Ribble Valley Borough Council
By email

Your ref: 3/2022/1062
Our ref: DC/22/4034
Date: 28-NOV-22

Location: Little Town Farm Chipping Road Thornley Preston PR3 2TB
Proposal: Proposed agricultural workers dwelling and farm office over detached garage.

Planning
Proposed Block & Site Plans

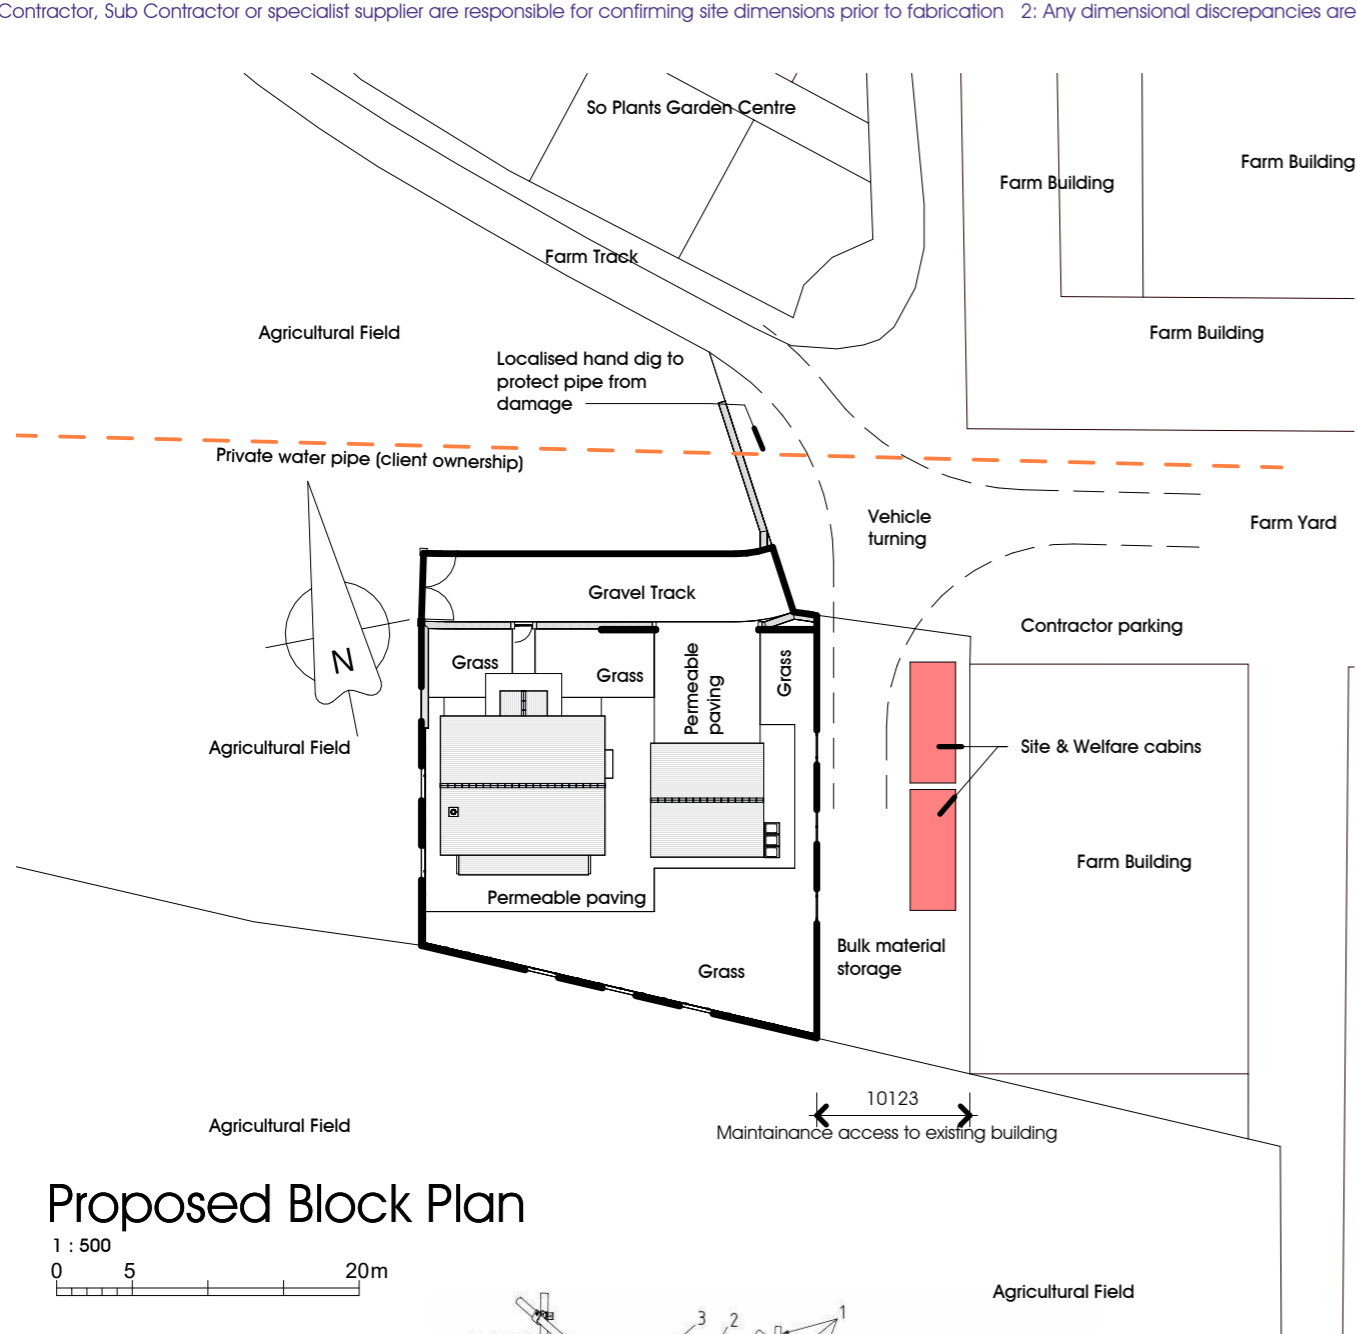
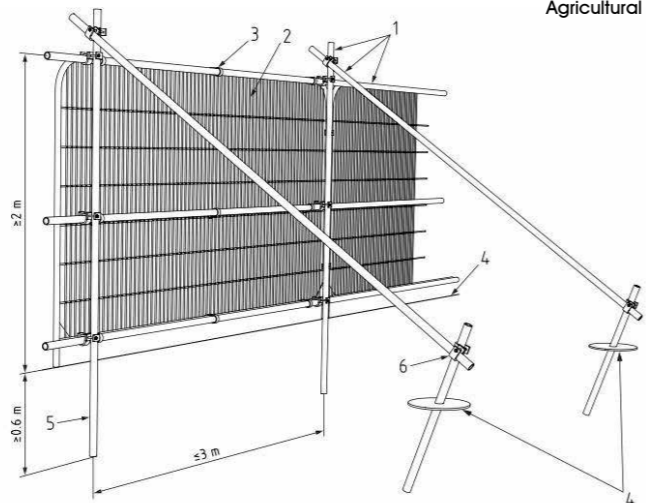
United Utilities will not allow building over or in close proximity to a water main.

A large diameter trunk main is in the vicinity of the site. It must not be built over, or our access to the pipeline compromised in any way. The Water Industry Act 1991 affords United Utilities specific rights in relation to maintenance, repair, access and protection of our water infrastructure. We require an access strip as detailed in our 'Standard Conditions for Works Adjacent to Pipelines', a copy of which accompanies this letter. The applicant must comply with this document to ensure pipelines are adequately protected both during and after the construction period. It also includes advice regarding landscaping in the vicinity of pipelines. Given the size and nature of the pipeline concerned, we strongly recommend that if they have

No construction shall commence until details of the means of ensuring the water main that is laid within the site boundary is protected from damage as a result of the development have been submitted to and approved by the Local Planning Authority in writing. The details shall outline the potential impacts on the water main from construction activities and the impacts post completion of the development on the water main infrastructure that crosses the site and identify mitigation measures to protect and prevent any damage to the water main both during construction and post completion of the development. Any mitigation measures shall be implemented in full in accordance with the approved details.
